WEST SUSSEX COUNTY COUNCIL CONSULTATION

TO:	Arun District Council FAO: Mr S Davies
FROM:	Jodie Wilkes West Sussex County Council Highways
DATE:	20/03/2018
SUBJECT:	P/20/18/DOC Approval of details reserved by conditions imposed under P/107/16/PL relating to conditions 3-surface water drainage, 4-schedule of materials & finishes, 5-landscape scheme, 6-screen wall/fence details, 8-site set up during construction, 10-storage of waste & recycling details , 11-placement of 2 No. nesting opportunities for birds & 14-external lighting details. 7, Webb Close, Pagham, PO21 4XB
DATE OF SITE VISIT:	
RECOMMENDATION:	☒ Advice ☐ Objection ☐ Modification ☐ No Objection ☐ More Information ☐ Refusal
S106 CONTRIBUTION TOTAL:	£N/A.

CONSTRUCTION LAYOUT

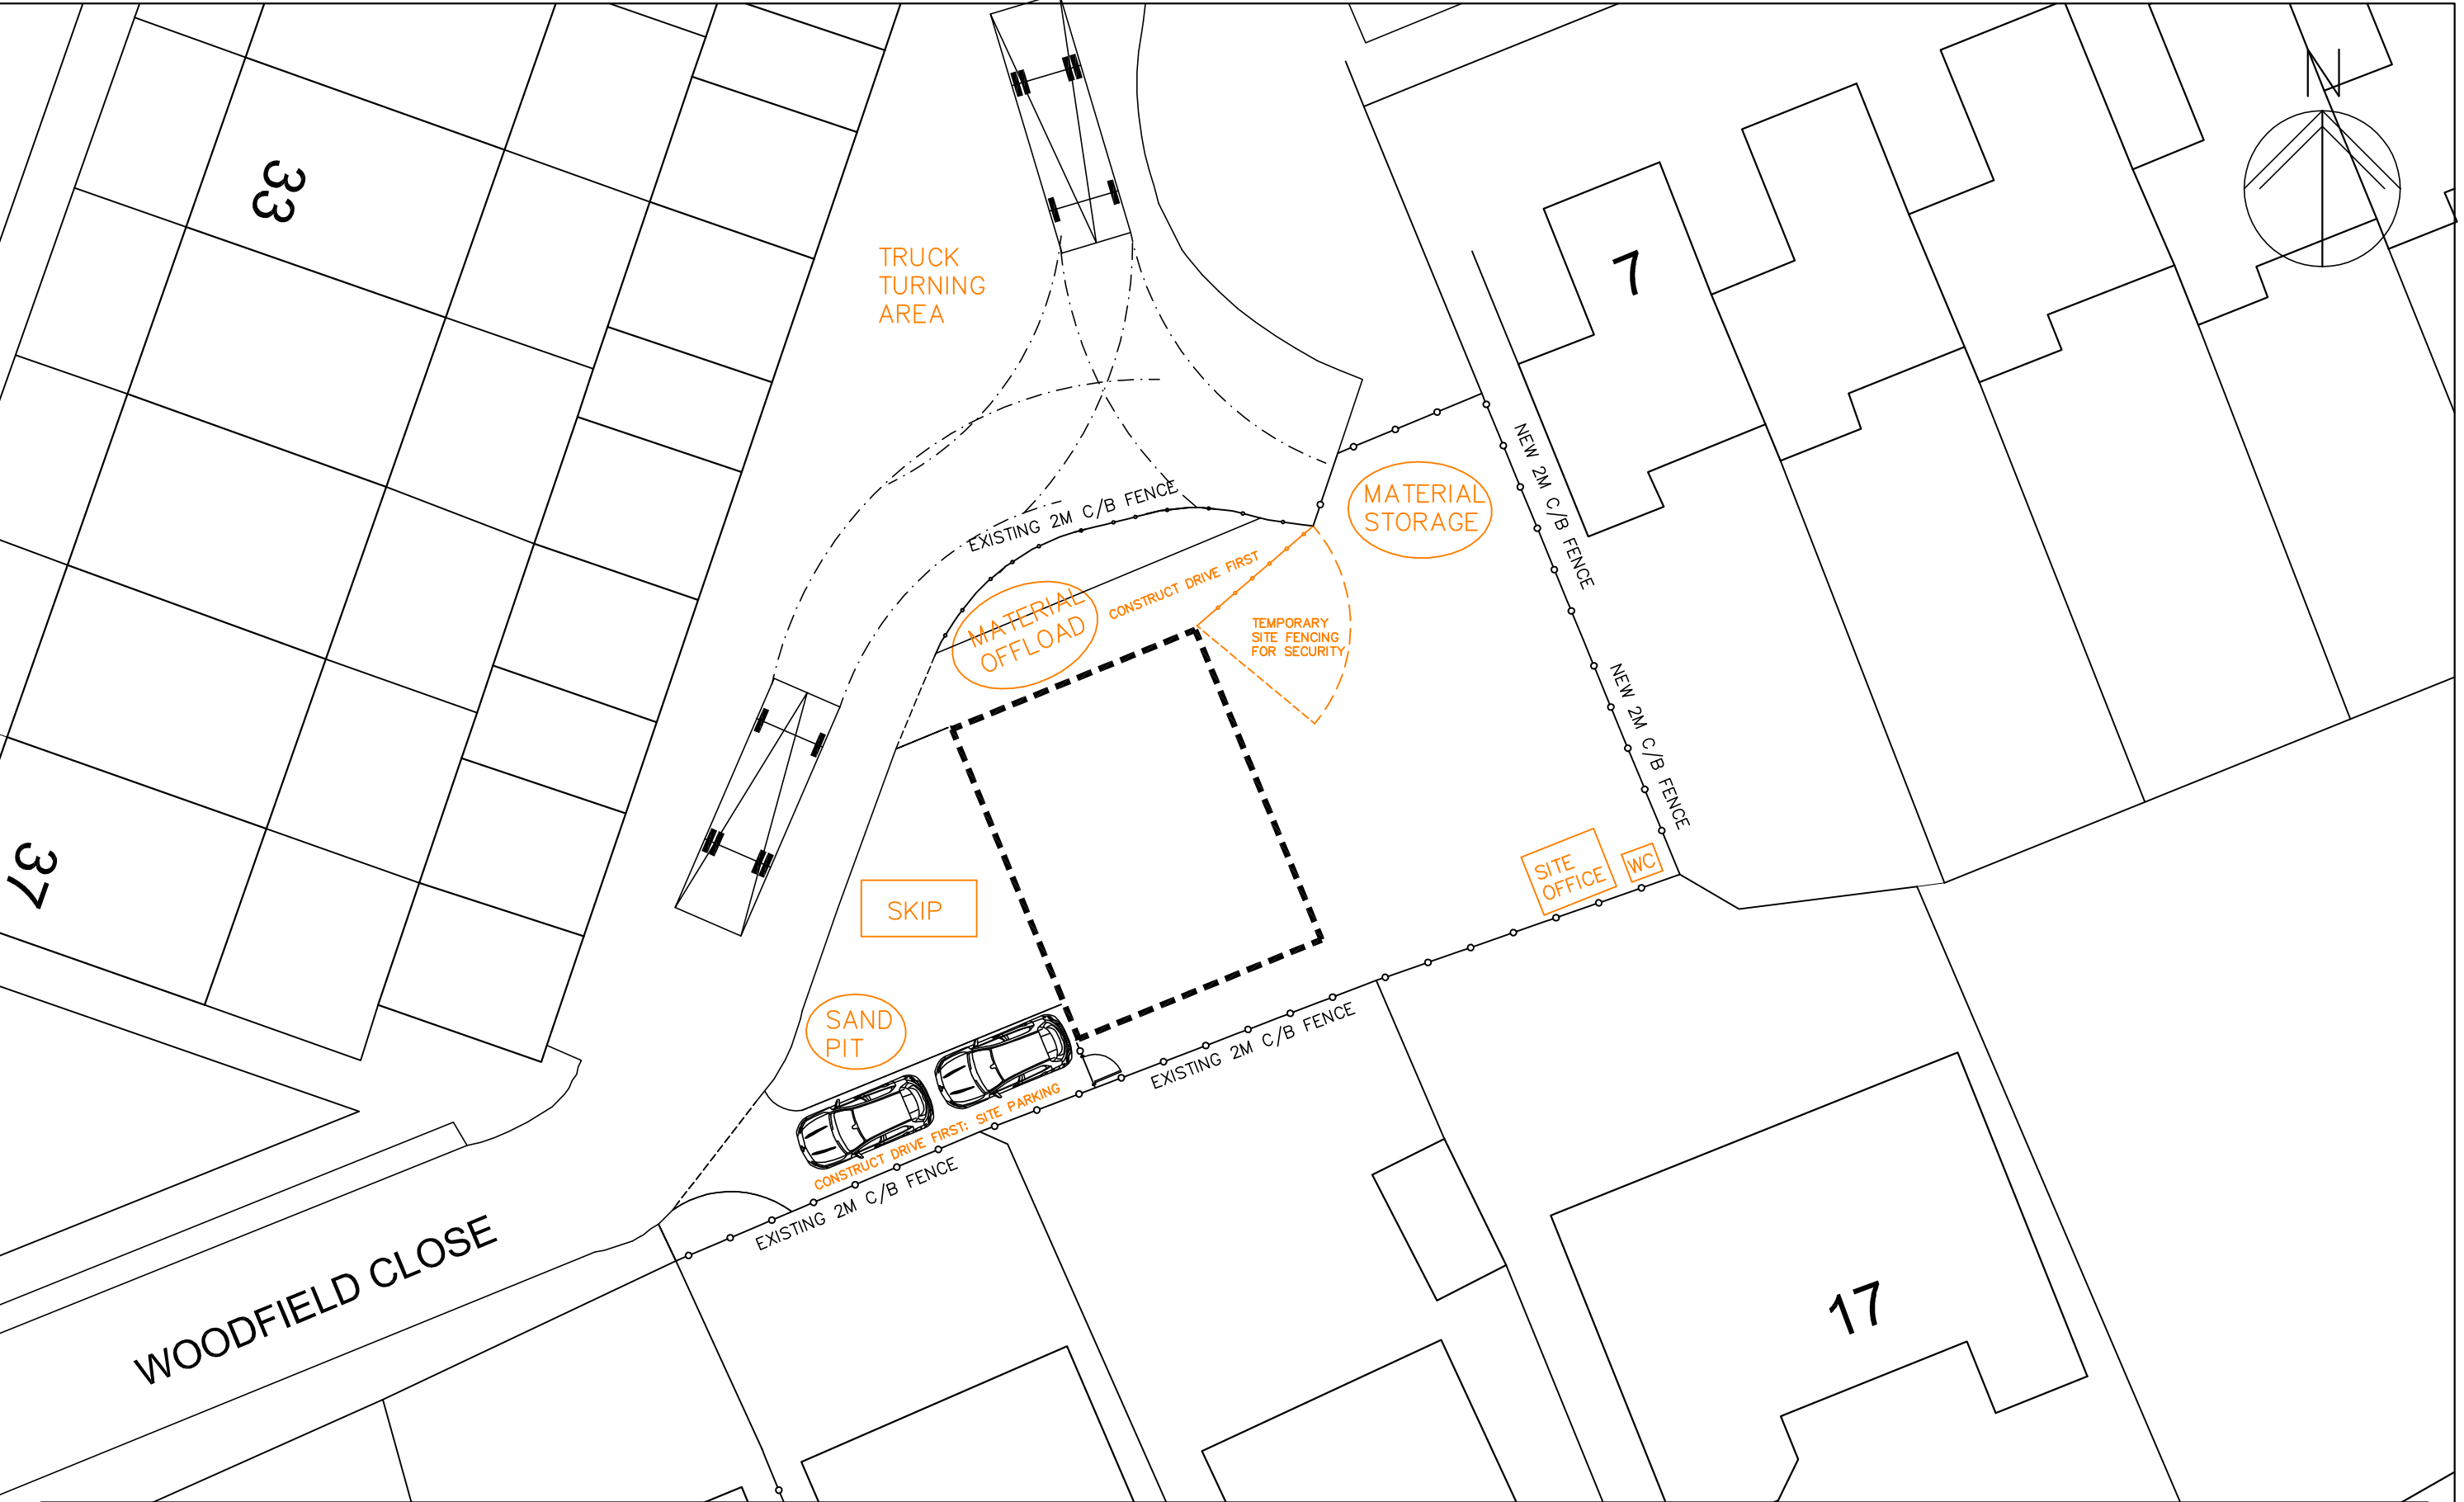
The LHA has assessed the submitted site plan outlining the site set up during construction. The plans demonstrate that the accesses will be provided prior to construction commencing, this allows contractors parking to occur off of the highway. Material offloading will occur within the site and skips and material storage are also all present within the site.

It has been noted that the carriageway leading to the development currently hosts an on street parking provision for residents. Whilst this is not an offense, the practise does clearly provide an obstacle for any vehicle larger than a car. Given the likelihood that deliveries will be via vans and small HGVs, the applicant will need to liaise with local residents regarding the time and size of the anticipated vehicles.

The LHA advises that any signage that may require placing in the highway to direct construction traffic or advising of the extra activity to this site will be required to be authorised by the Area Officer for this location, the officer can be contacted via telephone on 01243 642105.

Based upon the above the LHA consider that the condition may be discharged, subject to the applicant consulting with local residents regarding the parking arrangements.
